Landscape Design Review

Hinckley National Rail Freight Interchange (HNRFI)

Version 2.0
August 2023
Prepared by LUC

Fig 6. Parameters Plan and Key

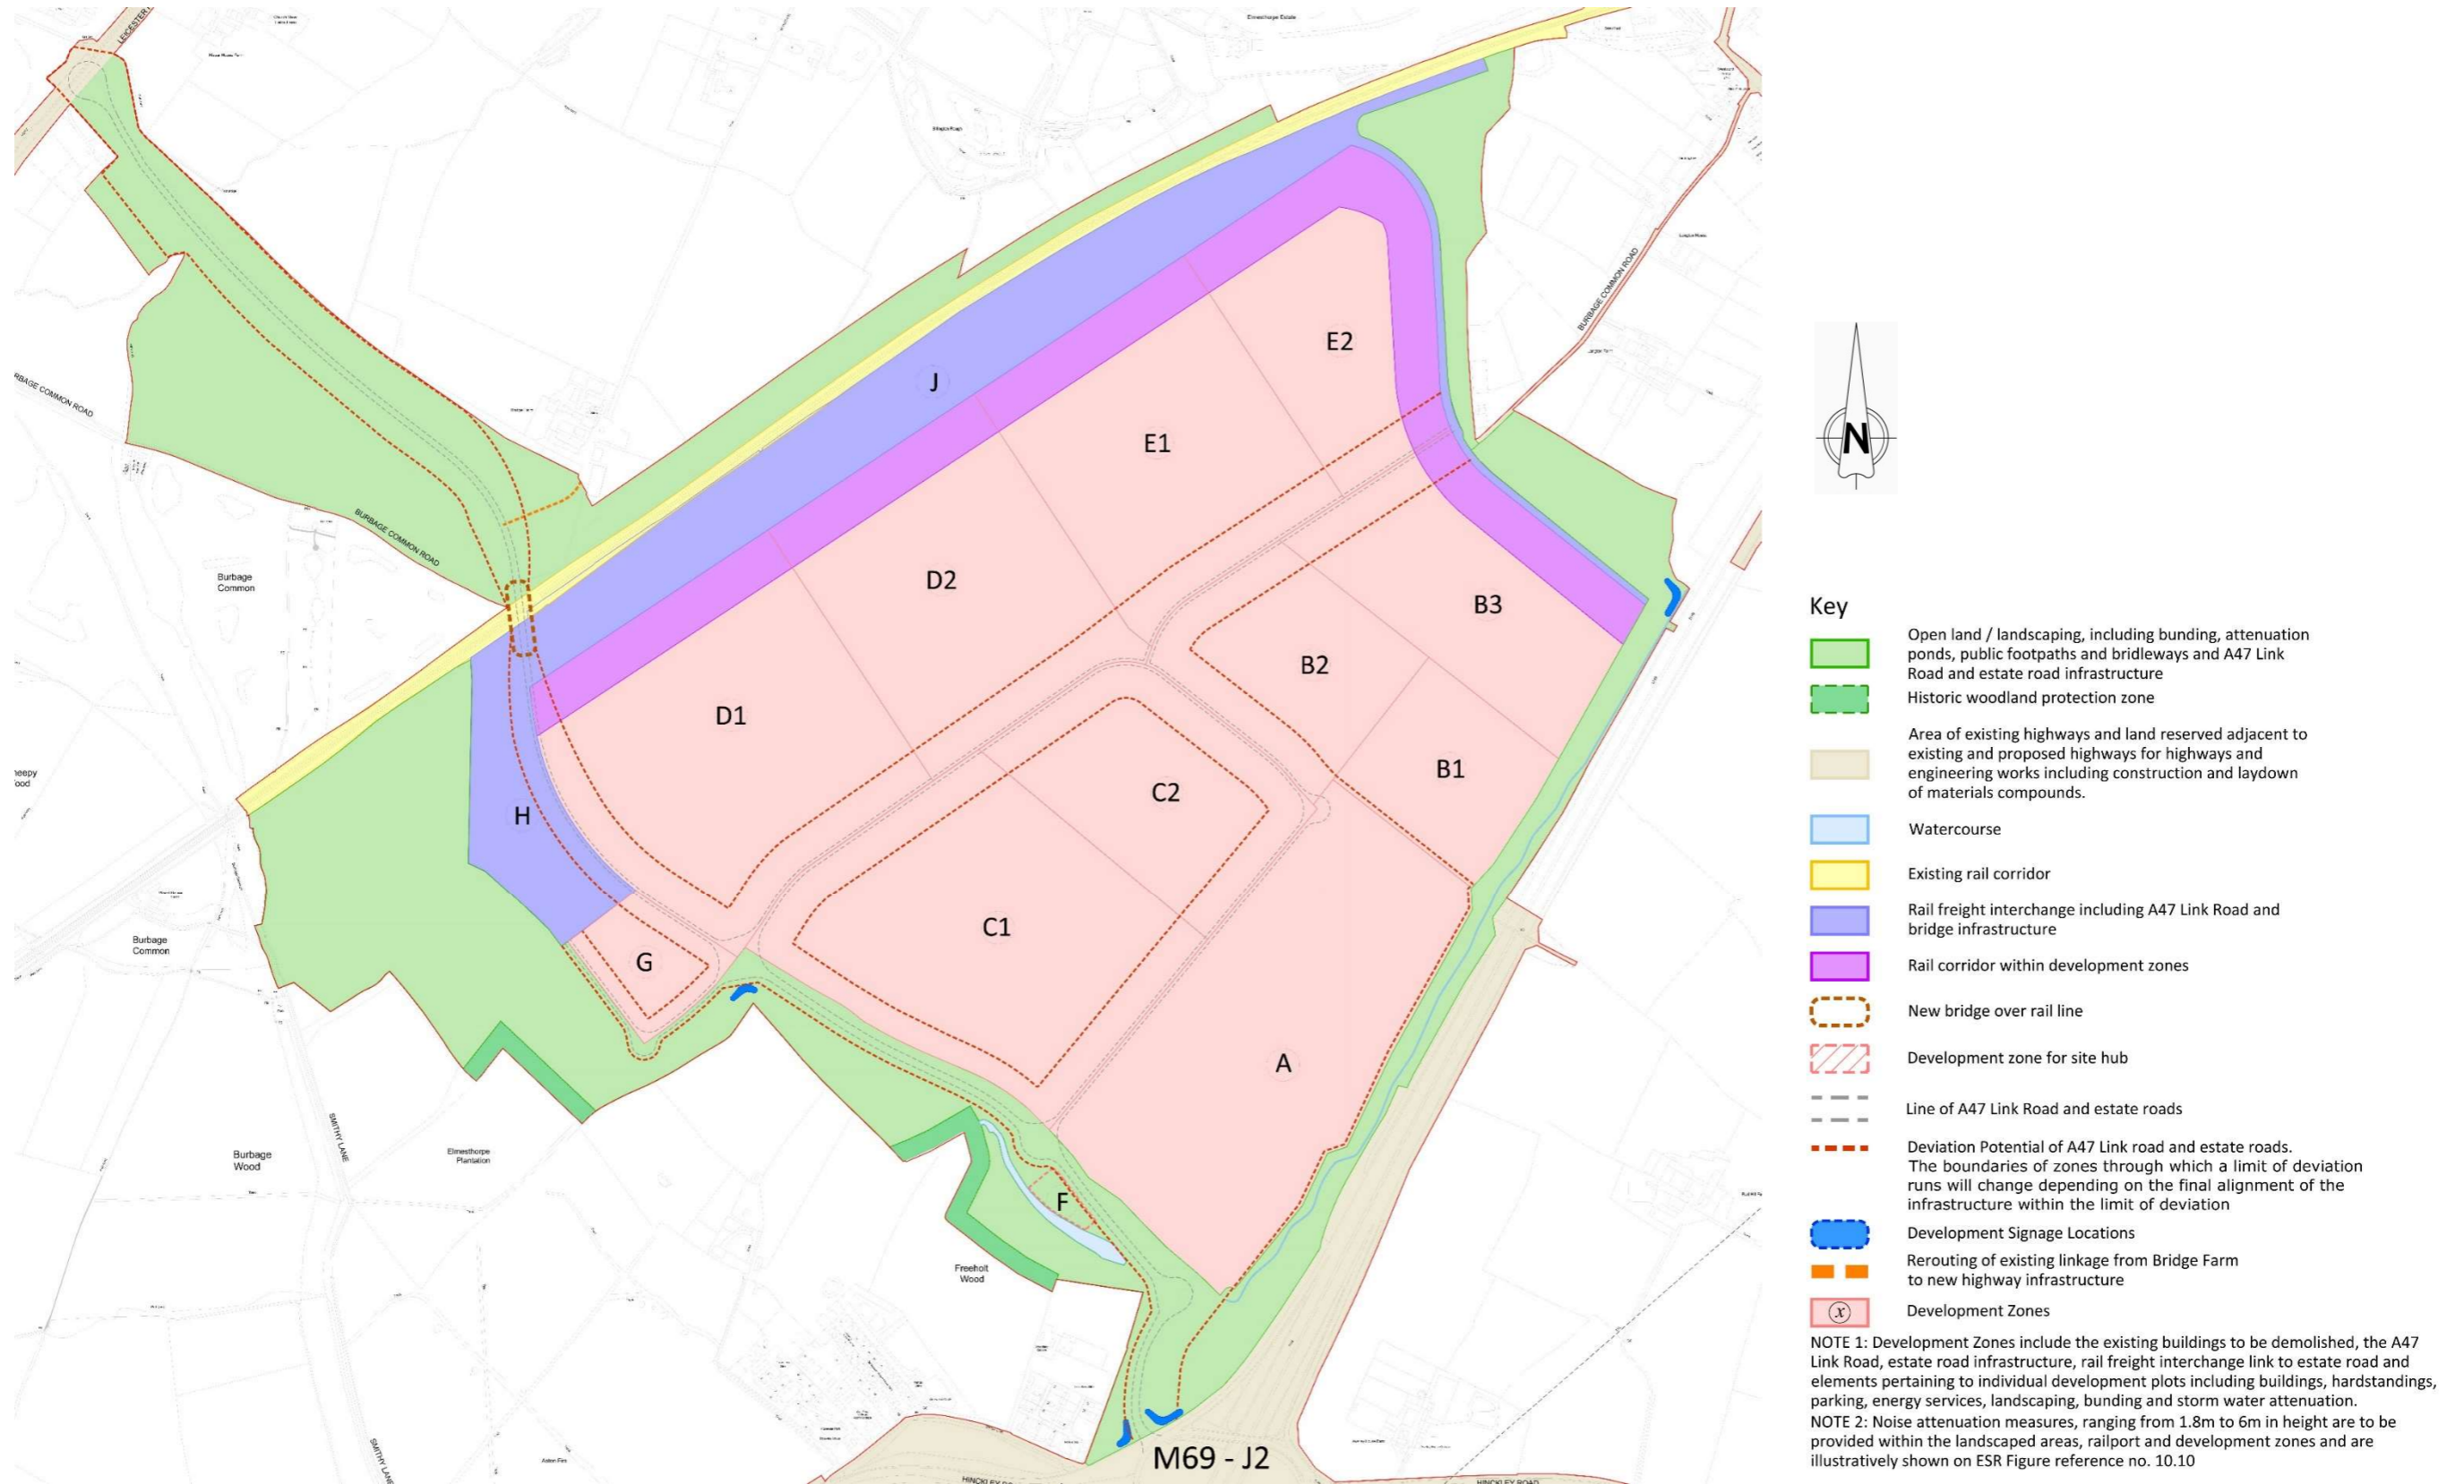
Although there has been an optioneering process to arrive at the current scheme which is welcomed, the process does not appear to have challenged the parameter plan (annex 1) which is fundamental in setting the development down it's current trajectory.

The parameter plan (Annex 1) dictates site clearance within its primary development zone and creates one large development plateau. This forms the majority of the site and removes the current grain of the landscape which integrates it into its context. Without this common grain the development is rather inward looking proposing a new layout that is more uniform lacking cohesion with its surroundings. The creation of a series of development plots responding to the existing levels of the site rather than to the rail levels appears not to have been considered.

Fig 17. Illustrative Public rights of Way

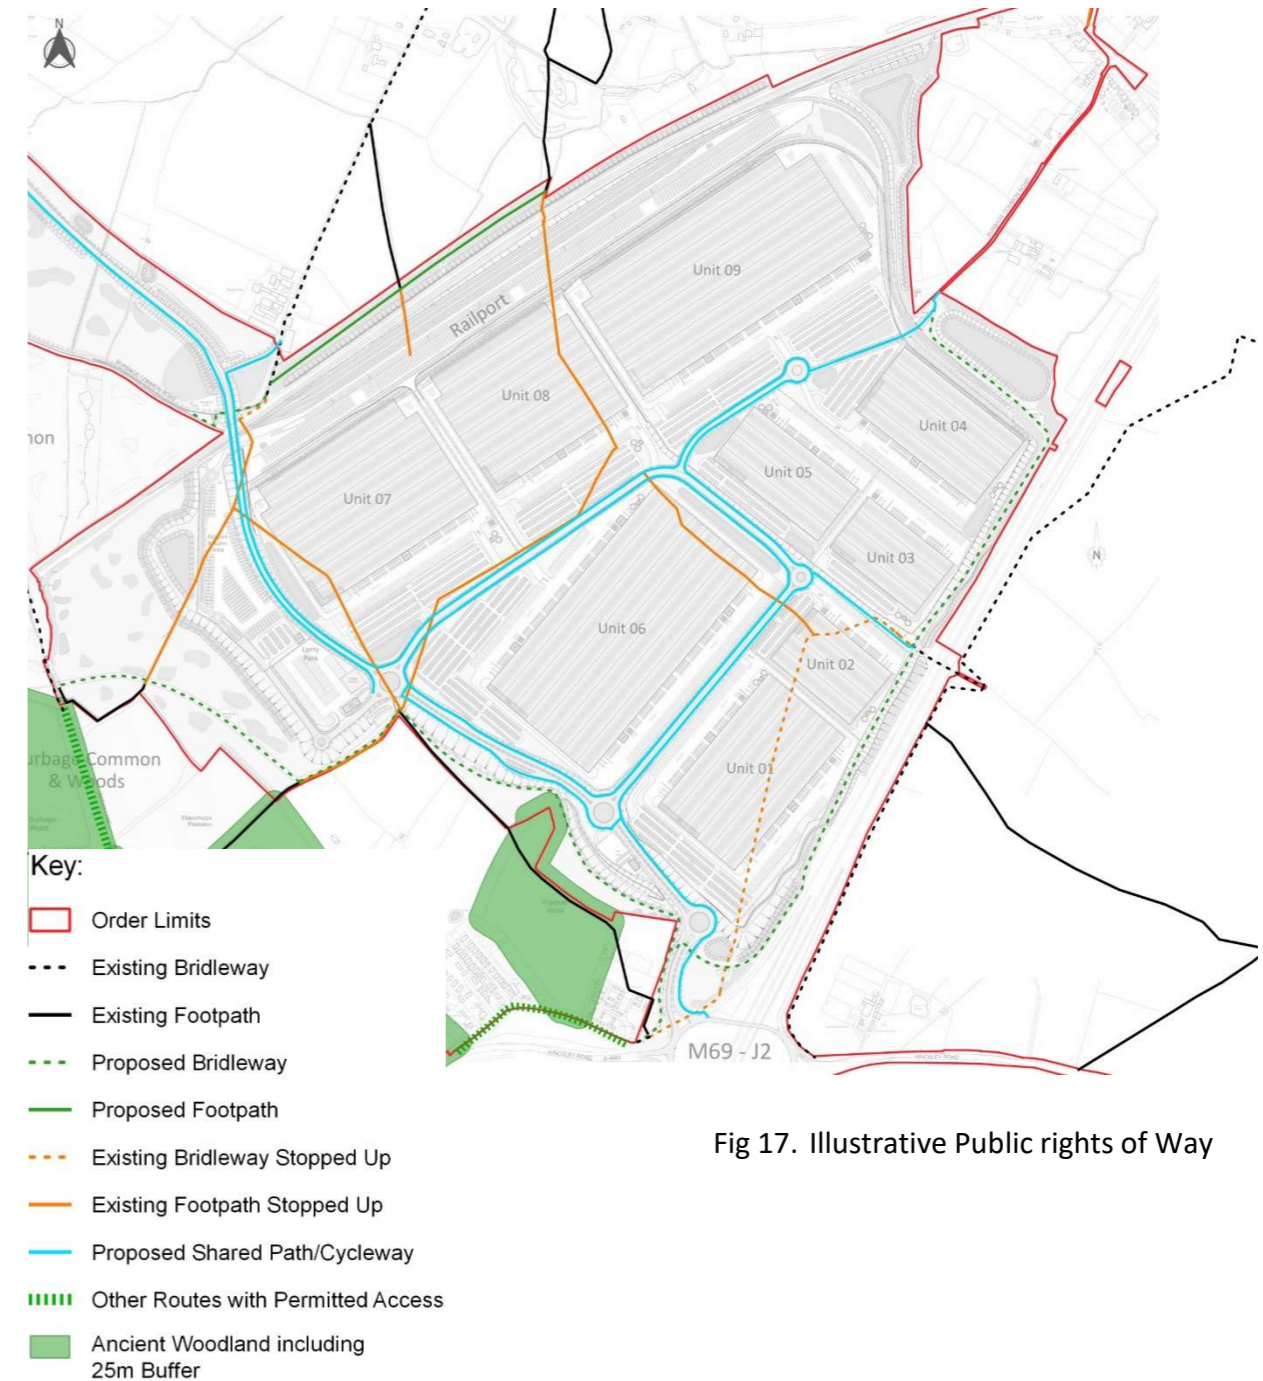
The existing public footpath and bridleways give varied rural routes permeating much of the site area. The proposals are to stop up and remove these PRoW, with re-provision being on the basis of pavements and cycleways running along large main roads, which will present an entirely different character (Annex 5). A new bridleway is proposed to the south of the site away from roads, this is welcomed but does not equate to the existing provision.

Fig. 35 – Typical Elevation Material Application

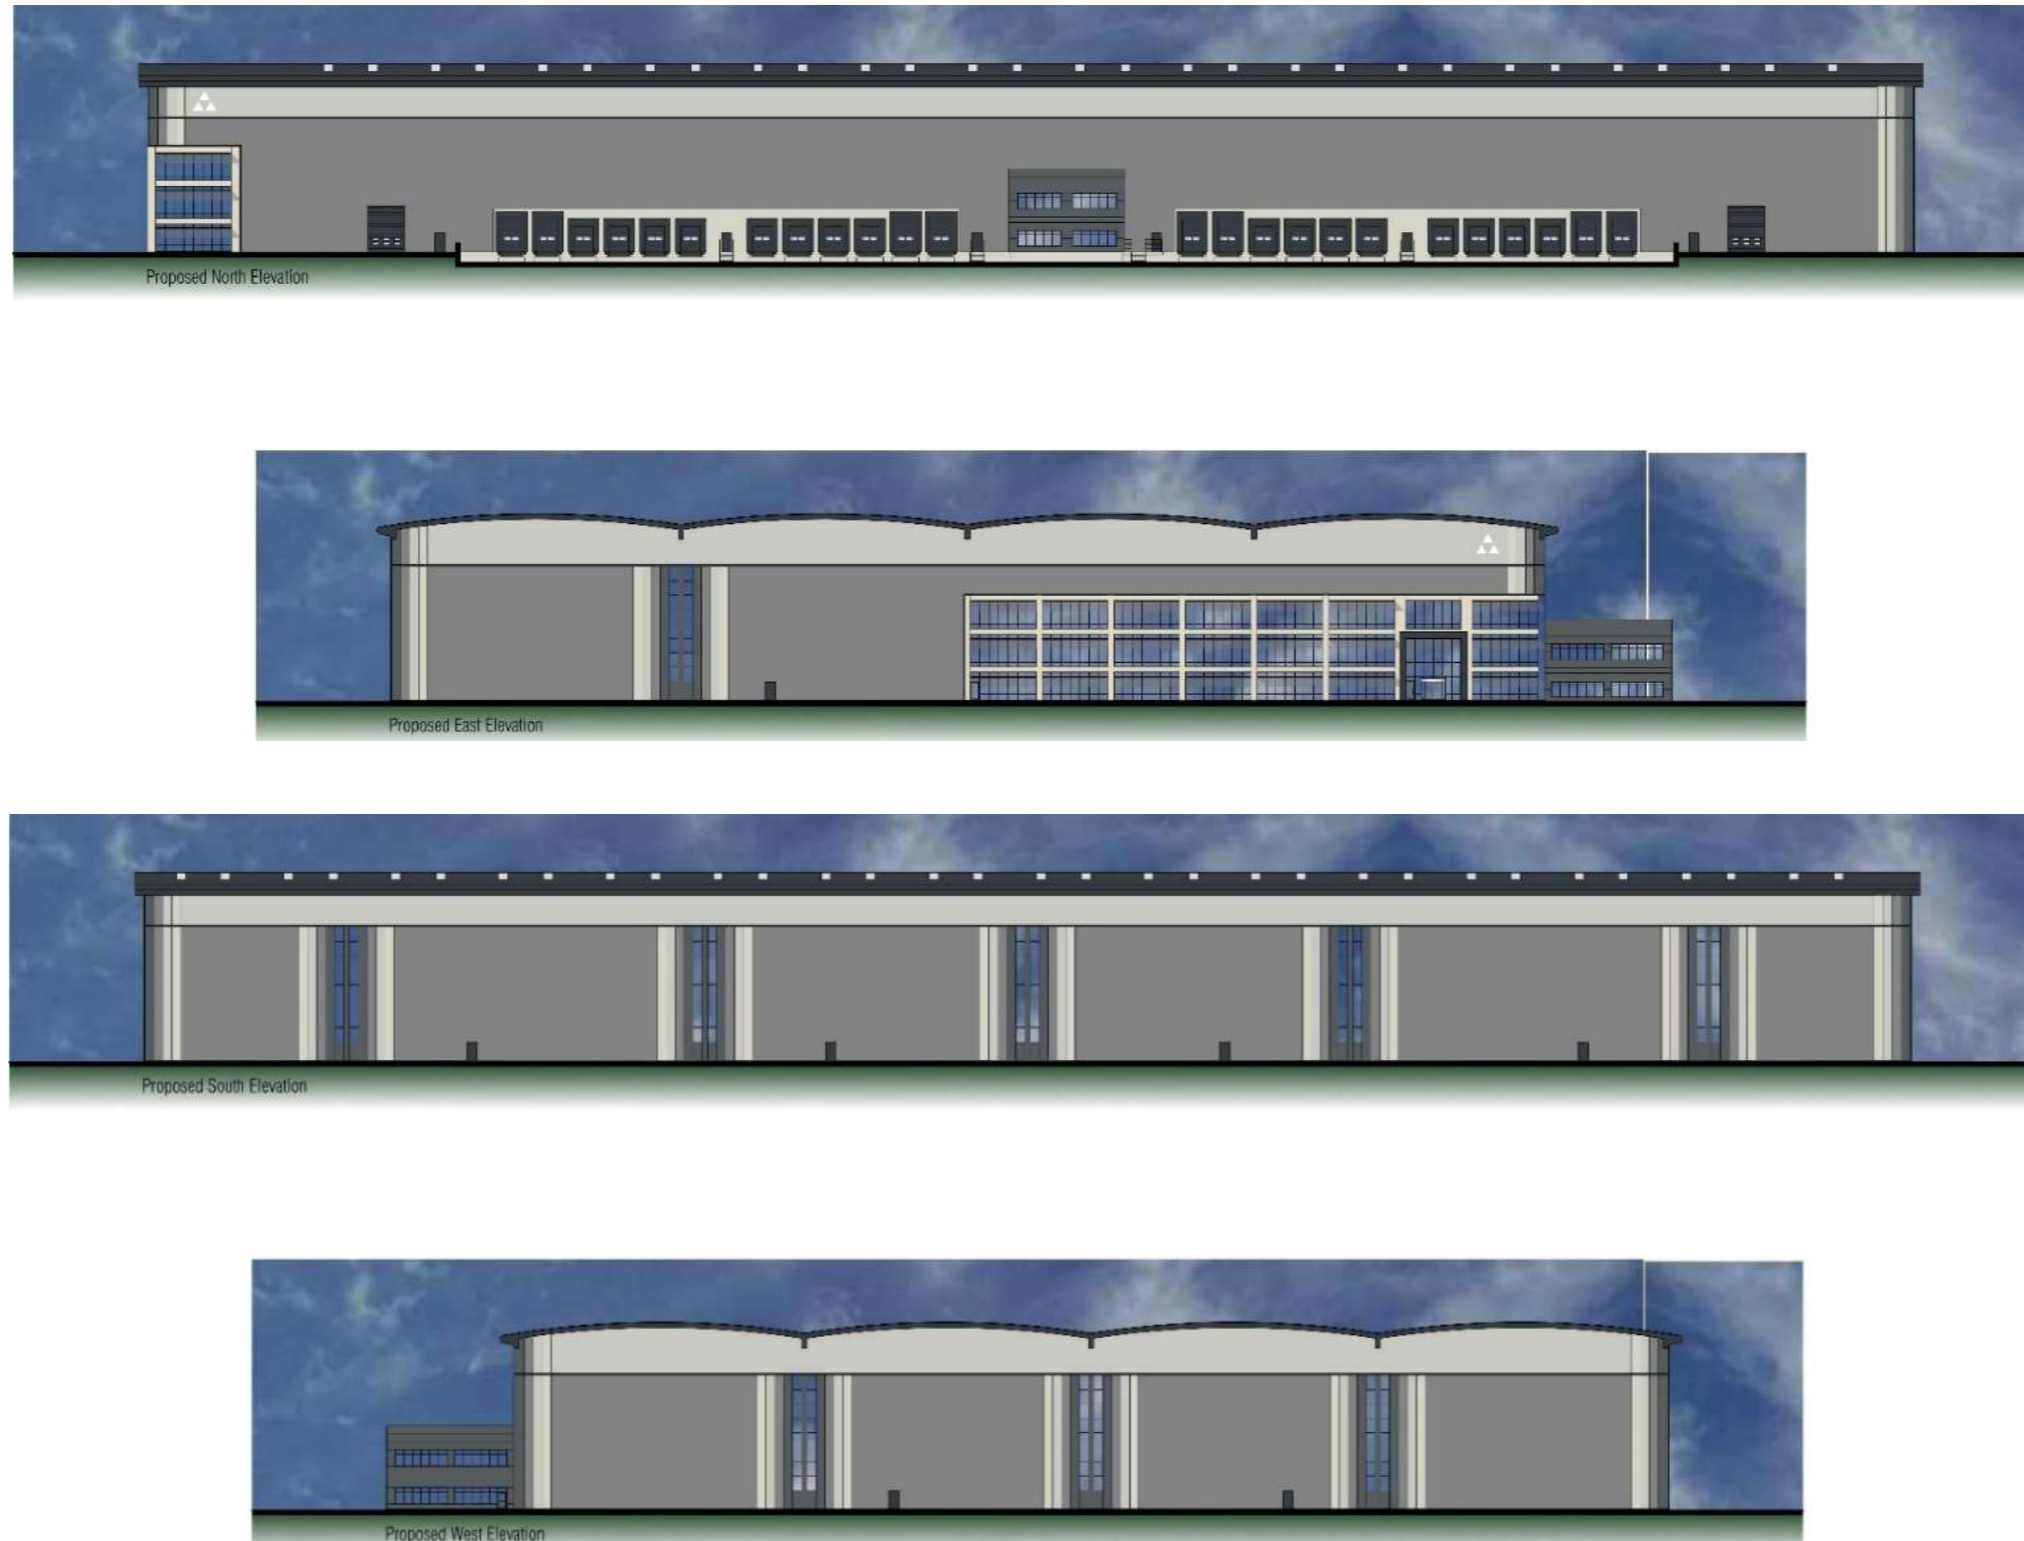
The proposed development does not reflect the local distinctiveness of the area identified within the landscape character descriptions or the local vernacular expressed within the local design guide. The proposals for the development are visually generic and similar to the developer's previous schemes elsewhere in the country. Although this generates a strong brand identity it's to the detriment of the local area contributing to an erosion of local character.
